DRB Application No.: 08DRB-70378

Project Name: ALVARADO GARDENS UNIT 3

CITY OF ALBUQUERQUE
PLANNING DEPARTMENT
DEVELOPMENT REVIEW BOARD

08DRB-70378 MINOR - PRELIMINARY/ FINAL PLAT APPROVAL

PLAT OF
TRACT 4-A
ALVARADO GARDENS UNIT 3
 BEING A REPLAT OF THE WEST 1/2 OF TRACT 4
 ALVARADO GARDENS UNIT 3

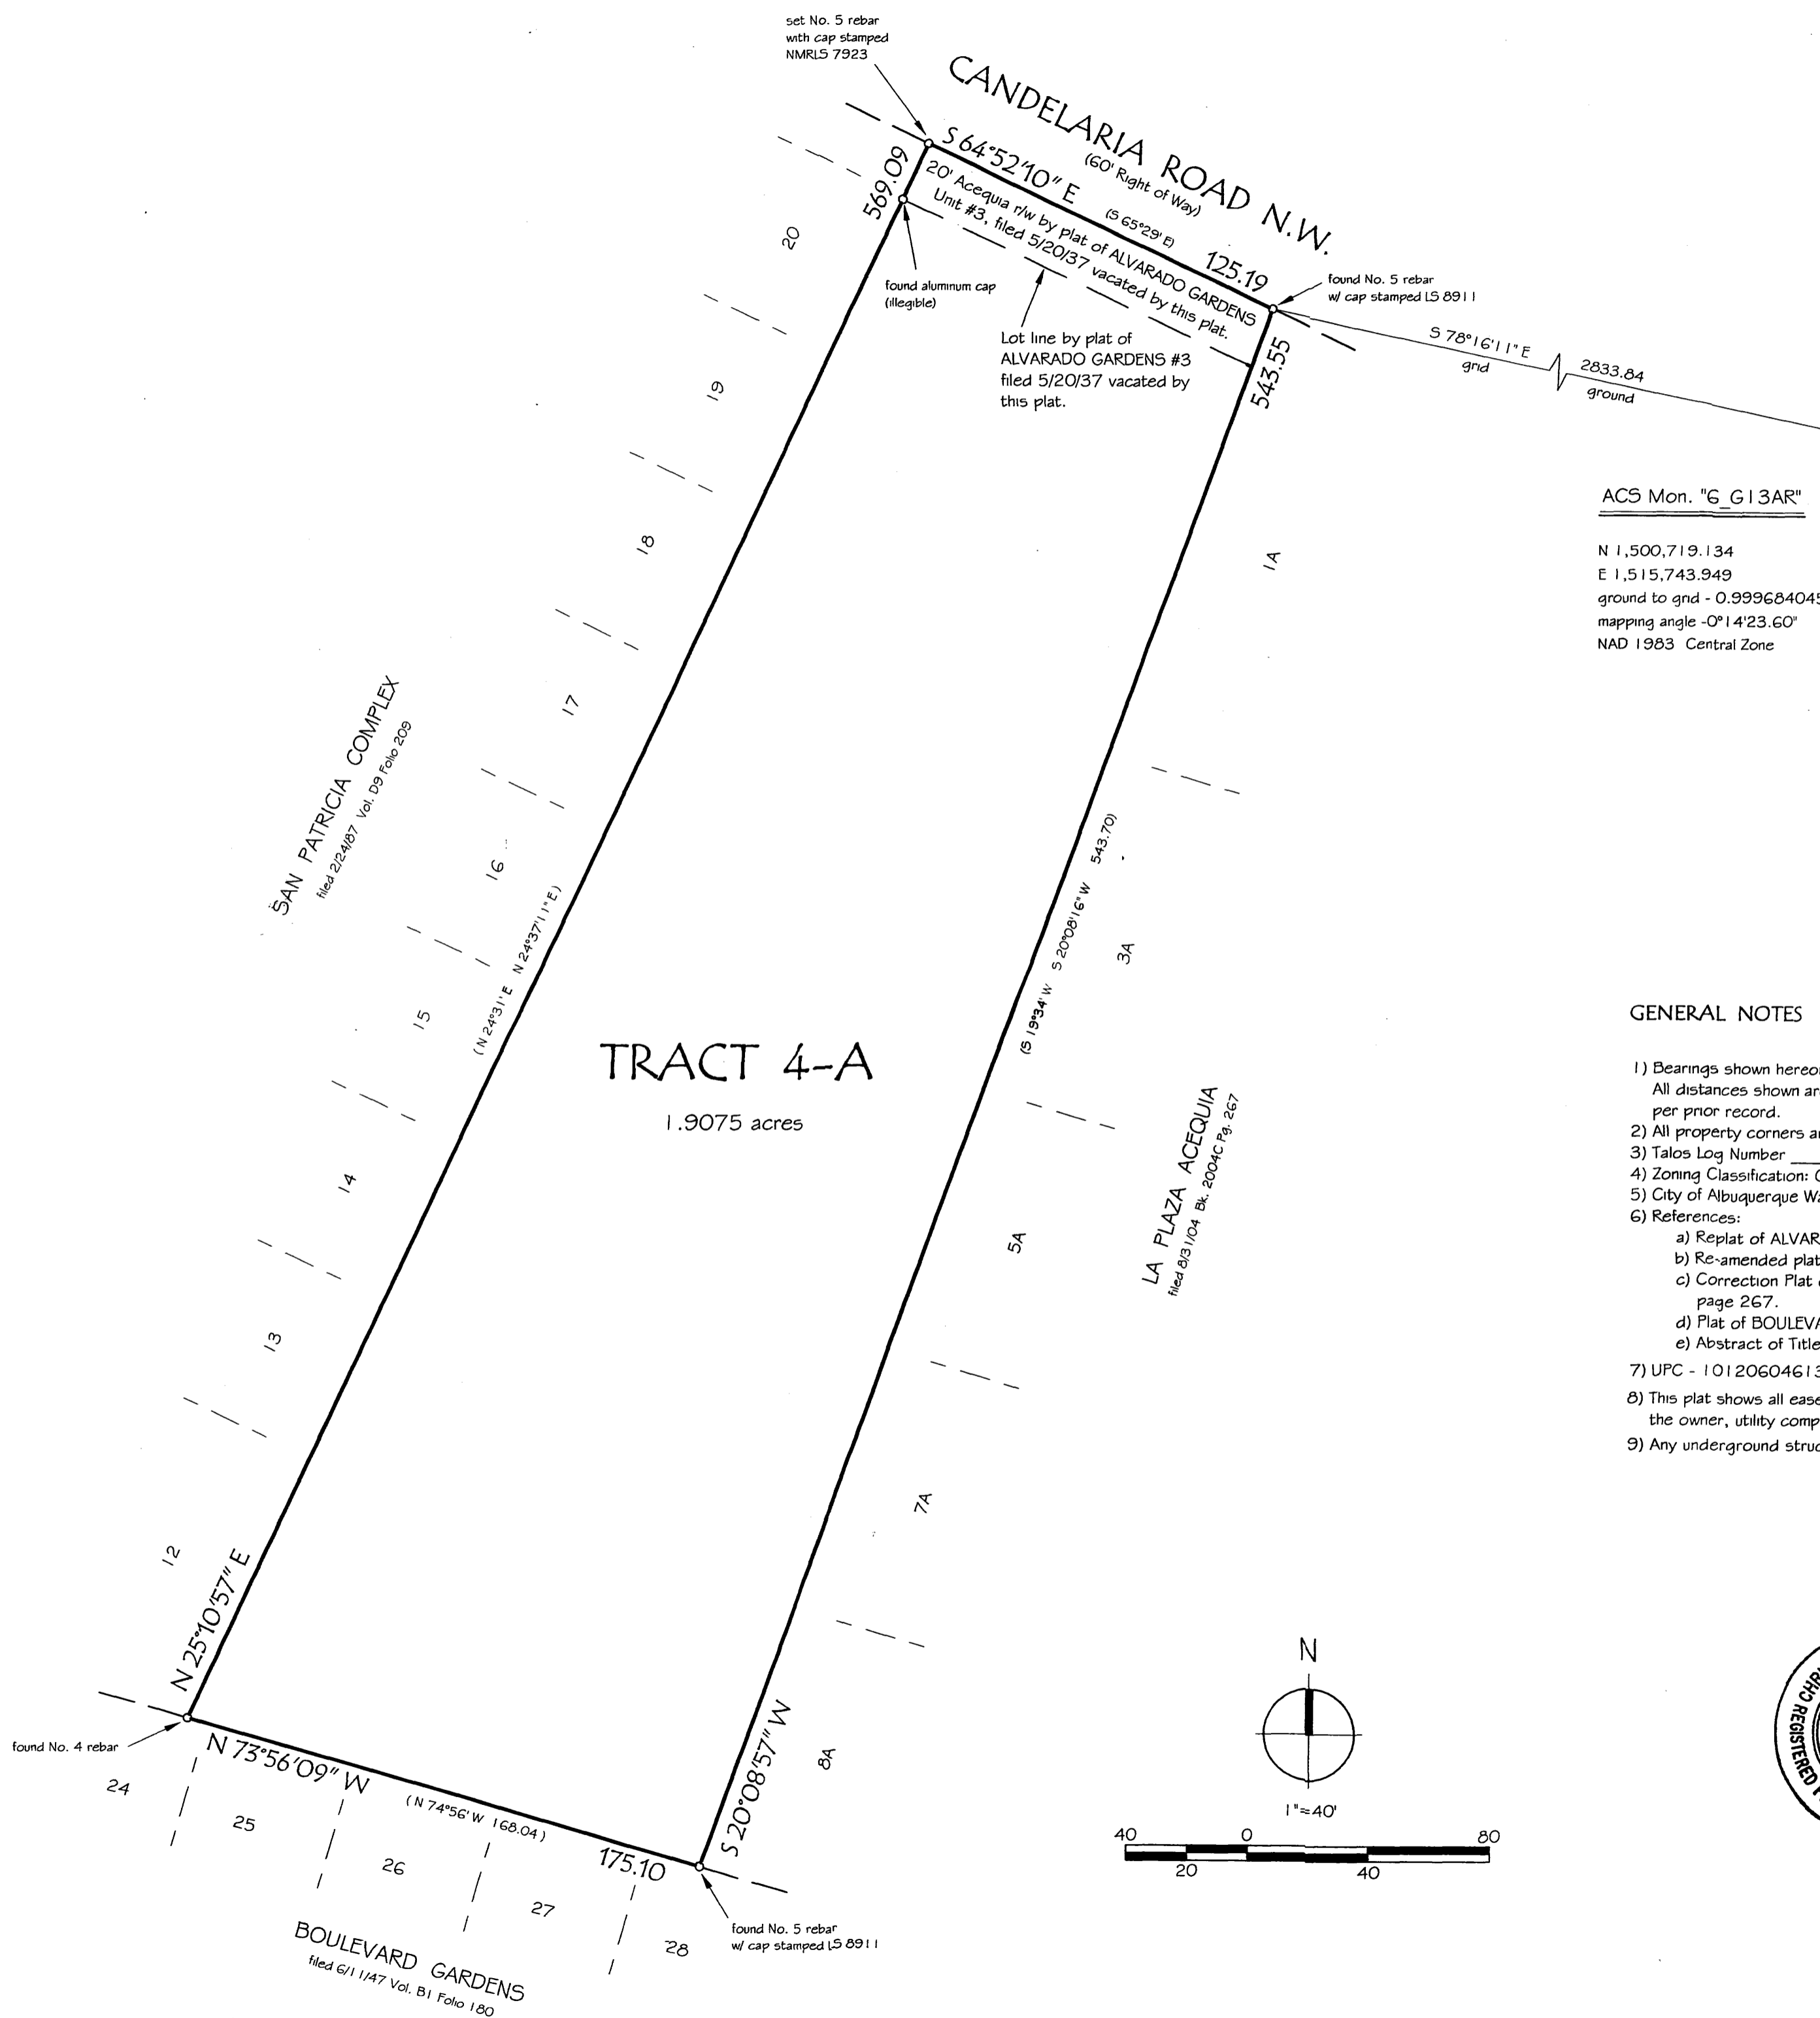
TRANSPORTATION: - exhibit showing improvements, distances

No comments provided
M.R.G.C.D 1. Previously reviewed on 08/21/2008. 2. MRGCD signed off for Final Approval on 08/27/2008.
OPEN SPACE DIVISION Open Space has no adverse comments
CITY ENGINEER The Hydrology section has no objection to the vacation request and no adverse comments on the plat.
TRANSPORTATION DEVELOPMENT No objection to vacation request. Provide an exhibit showing the location of sidewalk and defining the distance from face of curb to the property line. Right of way dedication may be required.
PARKS AND RECREATION Defer to MRGCD. No objection to the plat.
ABCWUA No objection to Vacation request. No objection to Plat approval.
PLANNING DEPARTMENT Refer to any Public Hearing comments regarding proposed vacation. A solar collector note per Section 14-14-4-7 of the Subdivision Ordinance is needed. Please remove Zoning note (No. 4).
